Former Buzz Bingo Bolton Road Banbury OX16 5UL

21/04202/F

Proposal: Redevelopment for 80 retirement living apartments including communal

SUMMARY OF RECOMMENDATION: THAT THE COMMITTEE CONFIRM THAT THEY WOULD HAVE REFUSED THE APPLICATION

Section A-A through Castle Street (proposed)

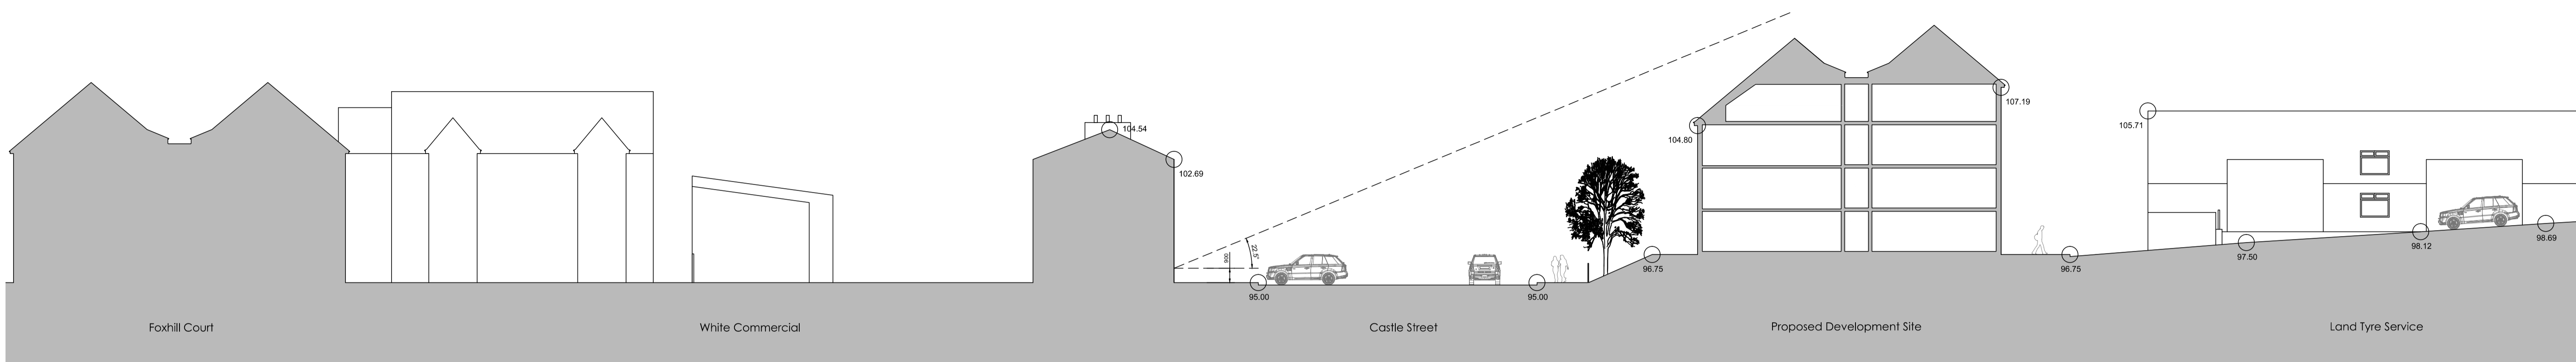
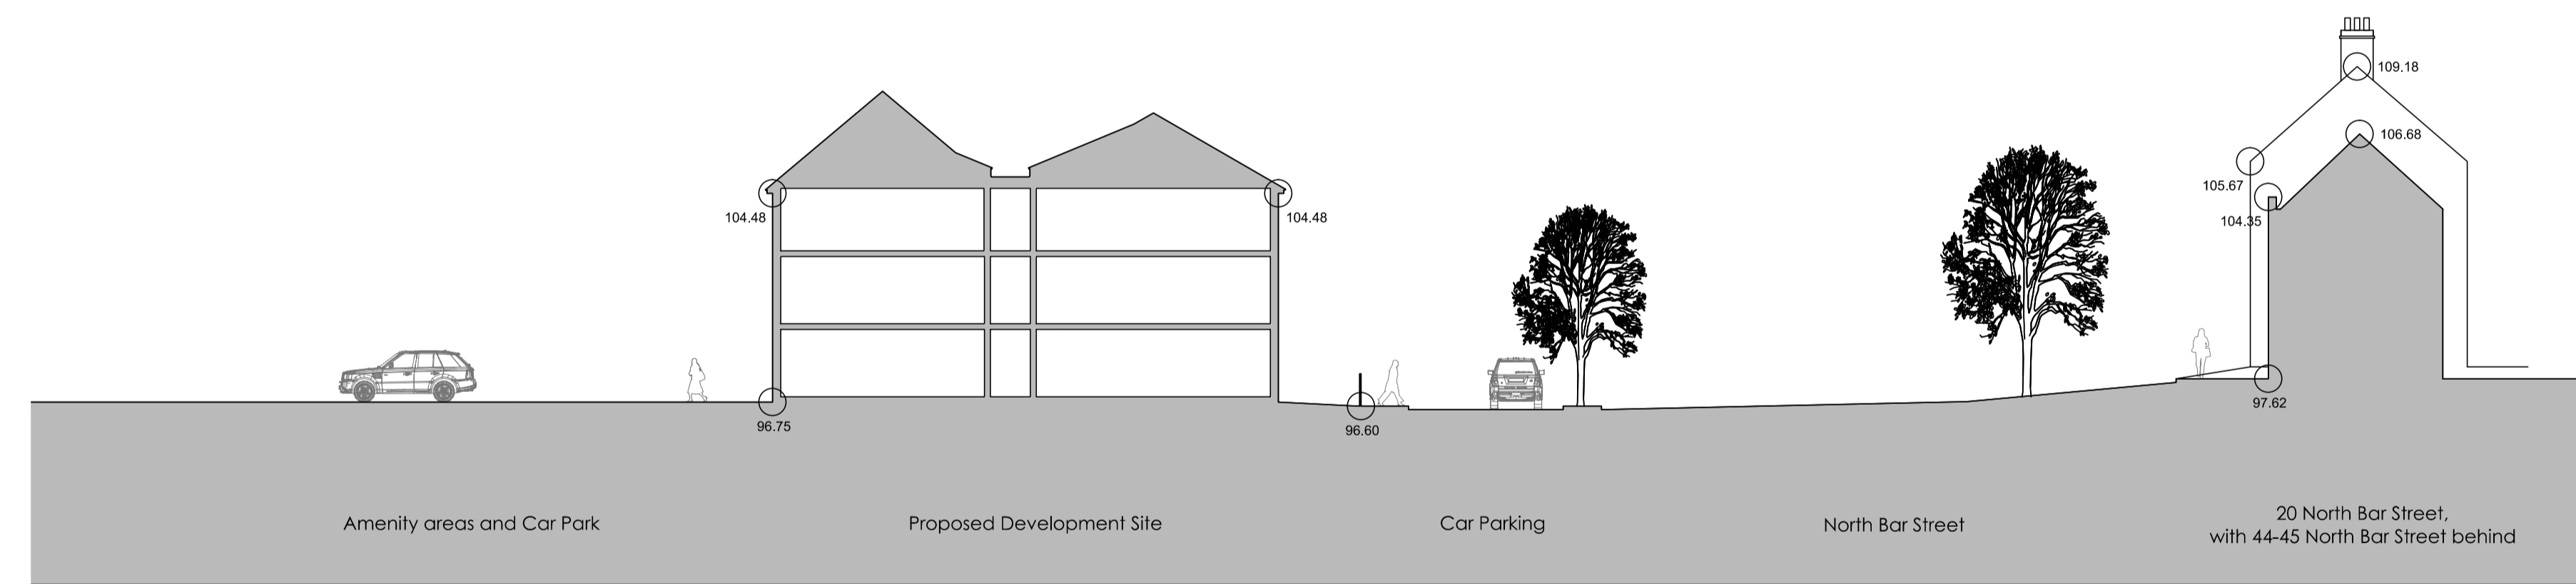
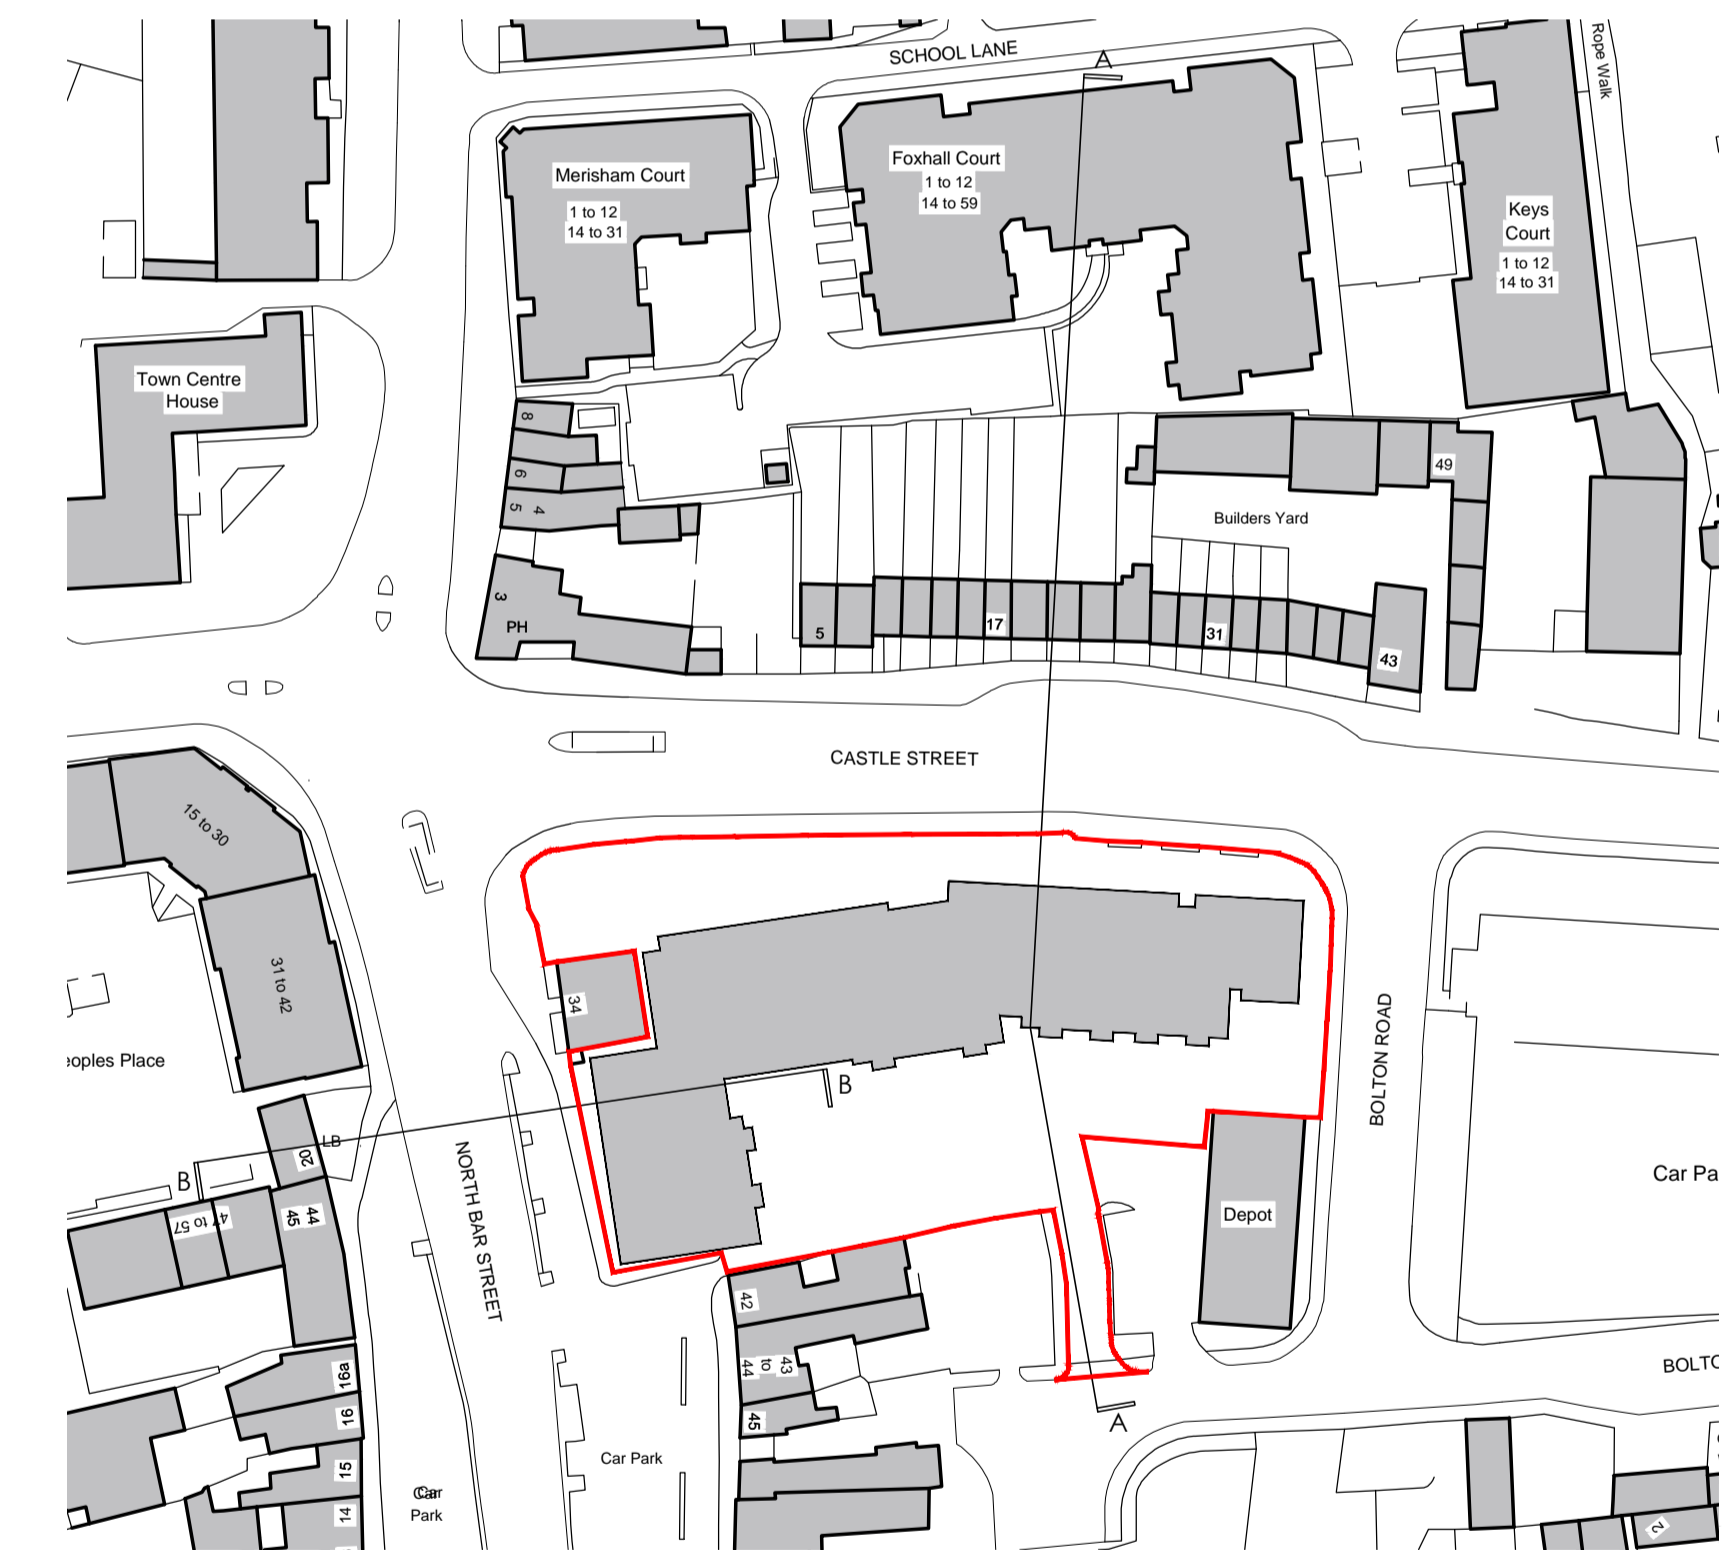
- 9.29. In terms of the Castle Street elevation, it is considered by the Conservation Officer that the 3 storey block which is set slightly above pavement level should be reduced to 2 storey beside Trelawn House and the space between the two also requires further consideration. As the roof is continuous and there is a stone band separating the second and third floor it looks quite monolithic as it lacks the usual plot width of traditional terraces, normally divided by chimneys and doors. Omitting the stone band and dividing the façade into typical 2-bay burgage plots would be more reflective of the north side of Castle Street. Juliet balconies are discouraged fronting the highway. The widths of the doors and windows look too wide and the band of masonry between ground and first floors too thin. The proportions of the white block are too squat and

together with the width and colour detracts from the scheme. The depth of the roof slope east of the white block creates a roof slope that is too big (compare with the lower 3-storey roof) and makes the development look contrived. A lower block might be better on this corner with Bolton Road.

- 9.30. The proposed development along North Bar is 3-storey. North Bar rises in a southerly direction and adjoins a modest 3-storey development with a higher eaves line. It is considered that here there might be an opportunity to have modest 3-storeys fronting the car park with slightly higher eaves aligning with the adjacent 3-storeys, stepping down to 2-storeys towards Trelawn House. In terms of detailing, the Conservation Officer also raises concerns with respect of materials, eaves, window proportions and door/porch detail.

Internal Elevation / North Elevation as proposed

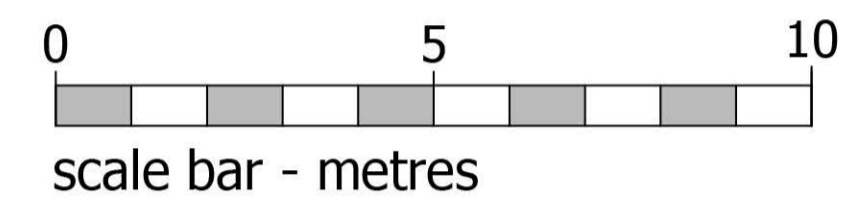
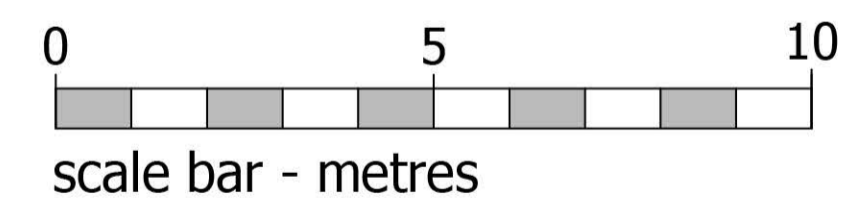
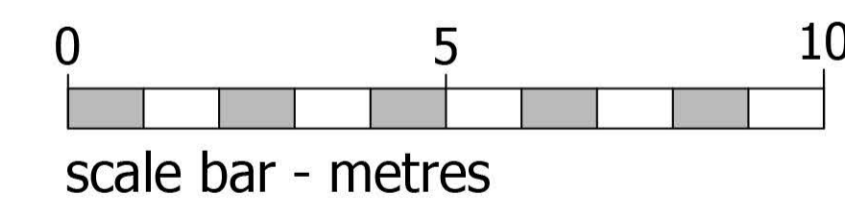
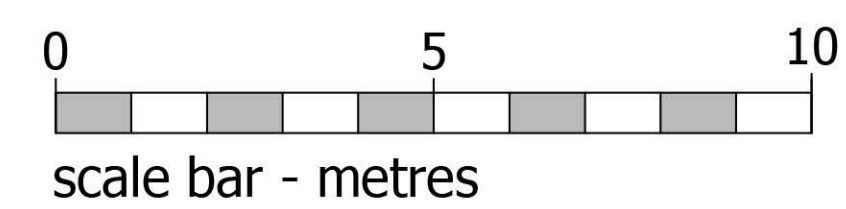
- 9.44. In terms of the views of the building down North Bar, the blank gable ends at ground floor level are unfortunate. Further consideration must be given to providing fenestration here and therefore natural surveillance to North Bar and the adjacent footpath link which currently runs down the side of buildings along North Bar to Bolton Road. This is one of the key pedestrian links which must be improved as part of the Banbury 8 re-development proposals in order to increase connectivity to and integration with the town centre for the general public. It is not clear from the submission how this aspiration is achieved to create a safe and inviting pedestrian link between the buildings and adjacent car park separated by retaining wall and railings from North Bar through to Bolton Road and the town centre.

- 9.47. Local traditional vernacular are simple flat fronted buildings with minimal detail. The proliferation of long narrow projecting rear gables are therefore not appropriate and do not respect the local traditional vernacular and historic buildings within the proximity of the site and the Conservation Area. Proposed dormer windows should be of traditional proportions and constructed in appropriate materials. It is noted that the plans state grey UPVC, but these would not be in keeping with the local traditional vernacular nor the traditional style of building proposed.
